## **Application by Highways England for an Order Granting Development Consent for the M42 Junction 6 Improvement**

### **The Examining Authority's written questions and requests for information (ExQ2)**

**Issued on 5 August 2019**

M6: Junction 25

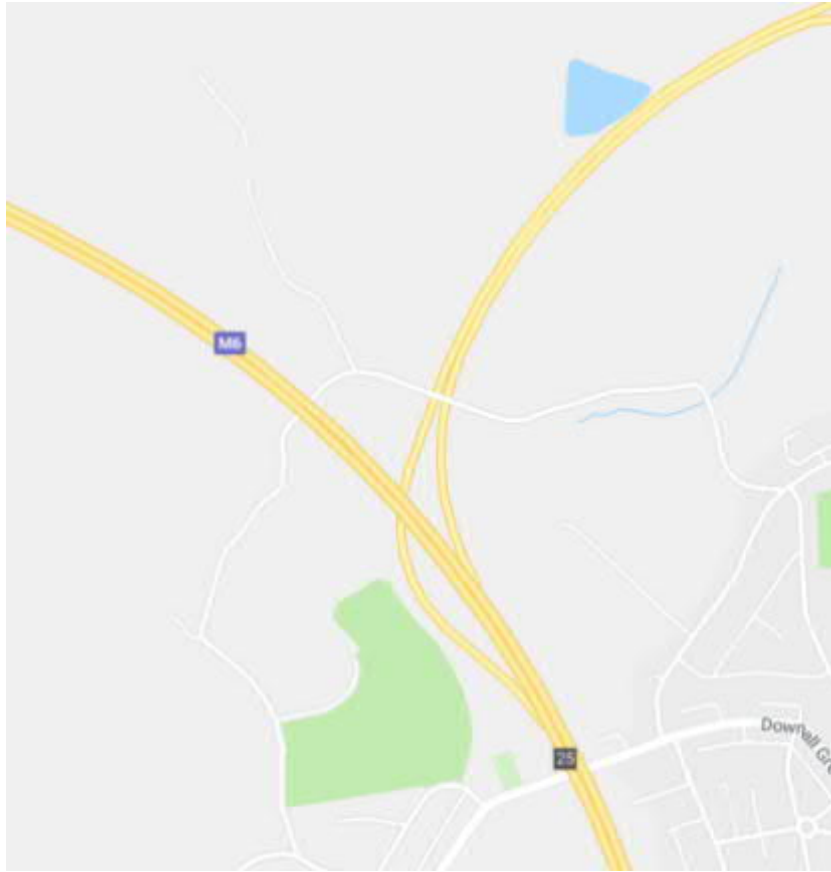
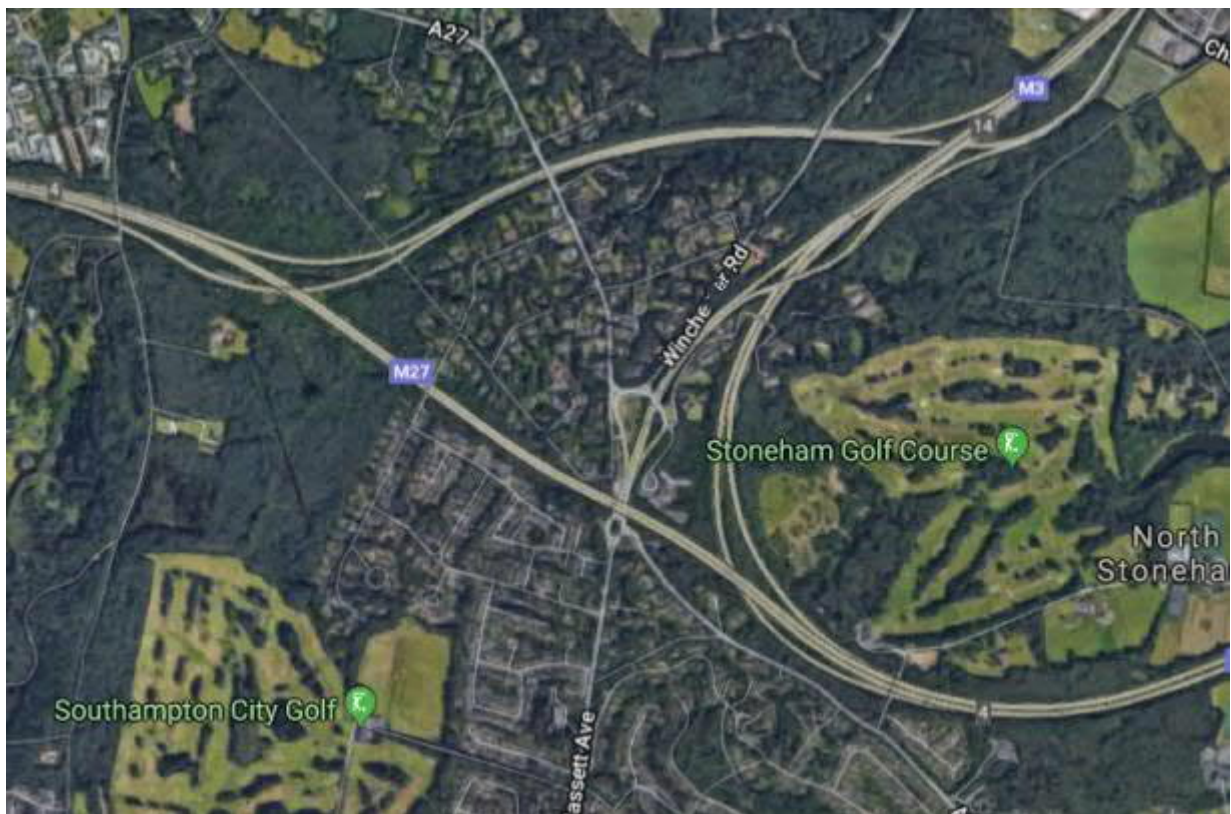
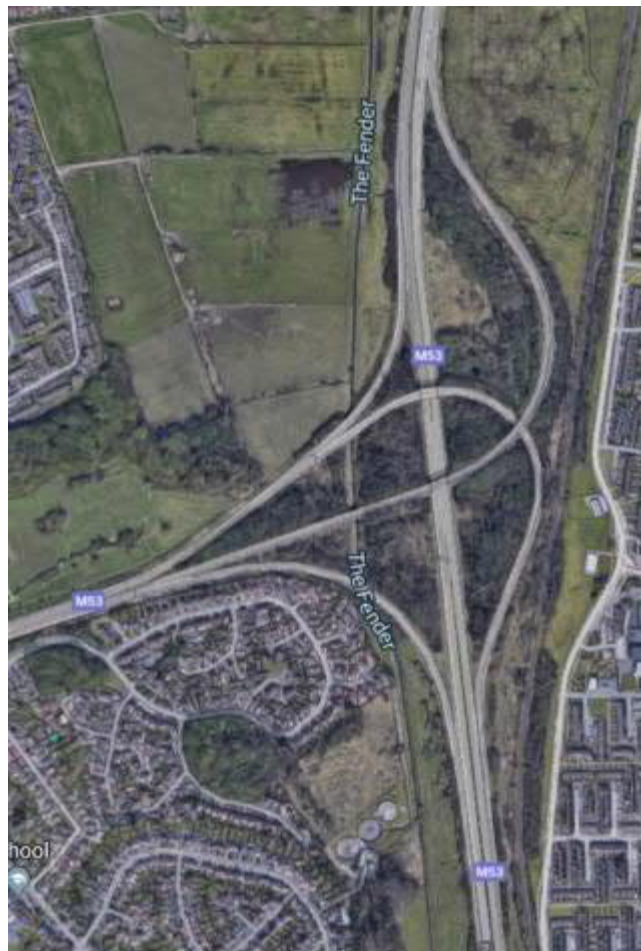
2.1.4.	The Applicant, SMBC, WCC, Extra MSA Solihull Ltd and Applegreen plc	<p><b>MSA and junction 5a</b>            It is evident from DMRB TD 22/06 figure 5/2 that the dumb-bell arrangement proposed would normally offer connections to 2-directional slip roads (in this case, N and S facing slips). How many junctions on English motorways are laid out in a dumb-bell arrangement but only with uni-directional slip roads?</p>

Figure 1: Main Site Compound - Consideration of Alternatives

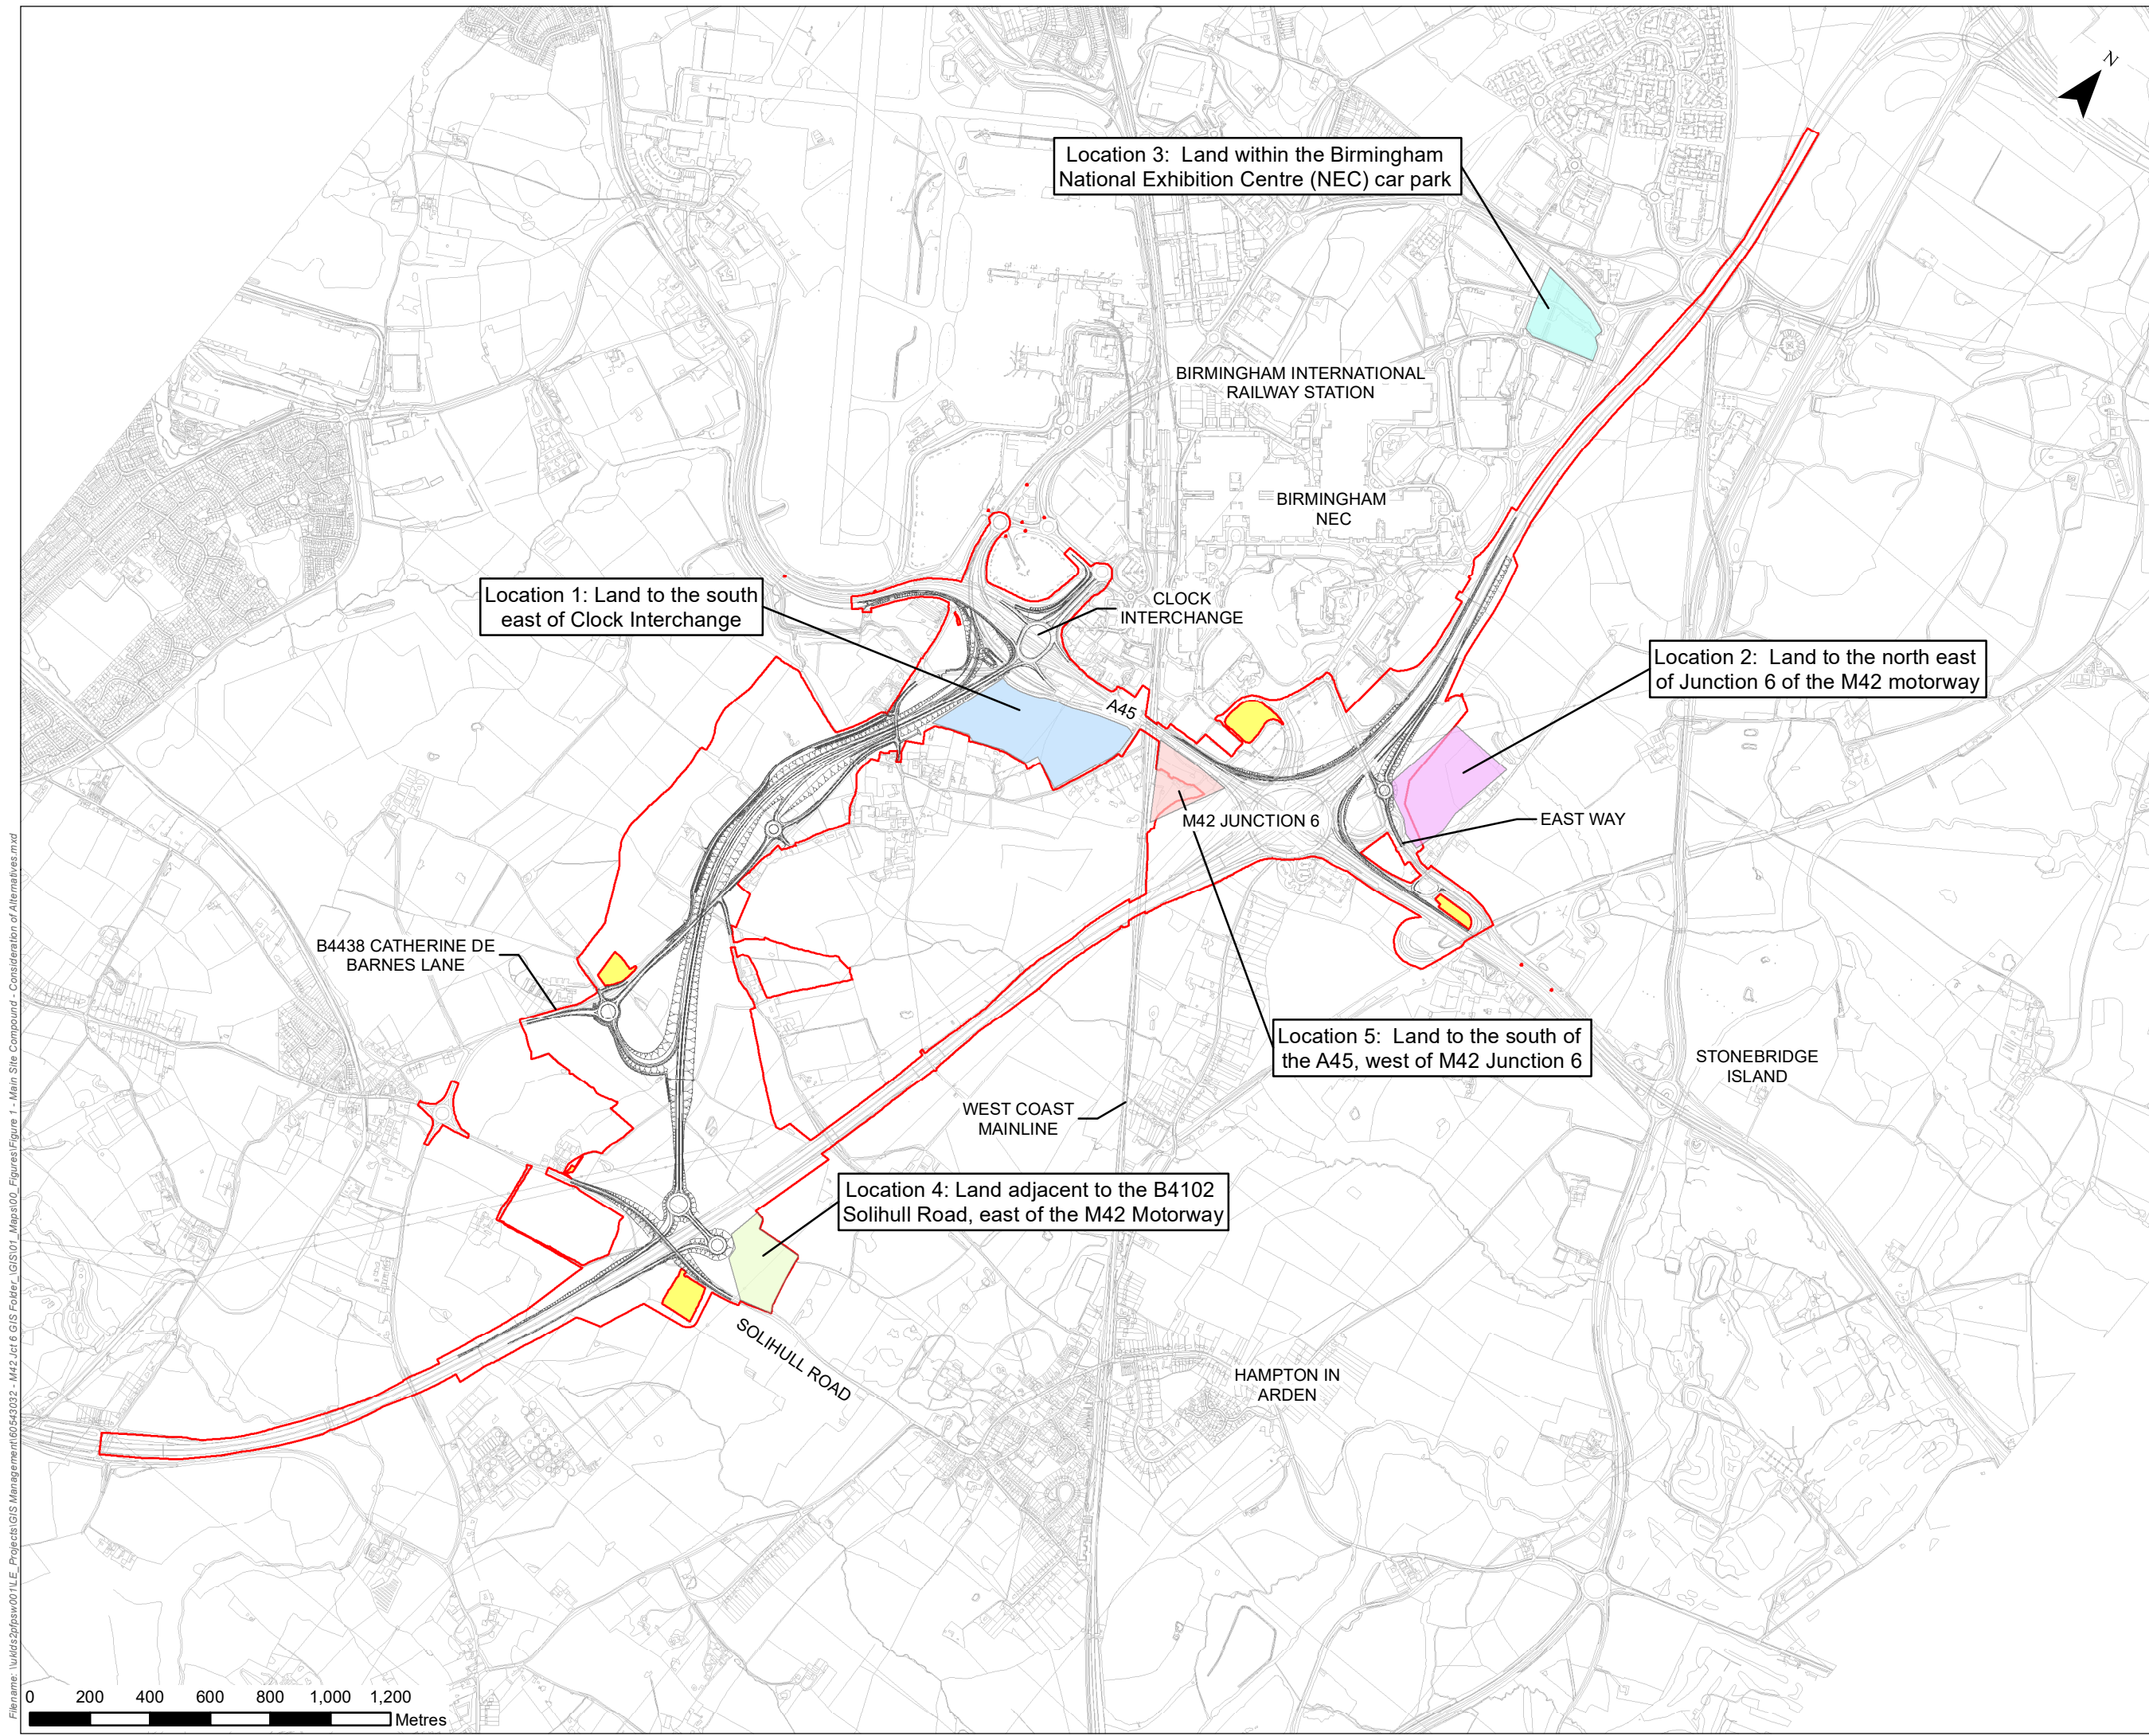
2.7.4.	Applicant	<p><b>Impact</b>                  ES paragraph 13.4.12 sets out a number of assumptions, including that land returned to agriculture following construction would be restored to its pre-construction condition. Can the Applicant explain what mechanisms would secure the pre-construction condition of the land, particularly that land to the south of the A45 corridor which would be used for the main site compound (Work No. 69)?</p>
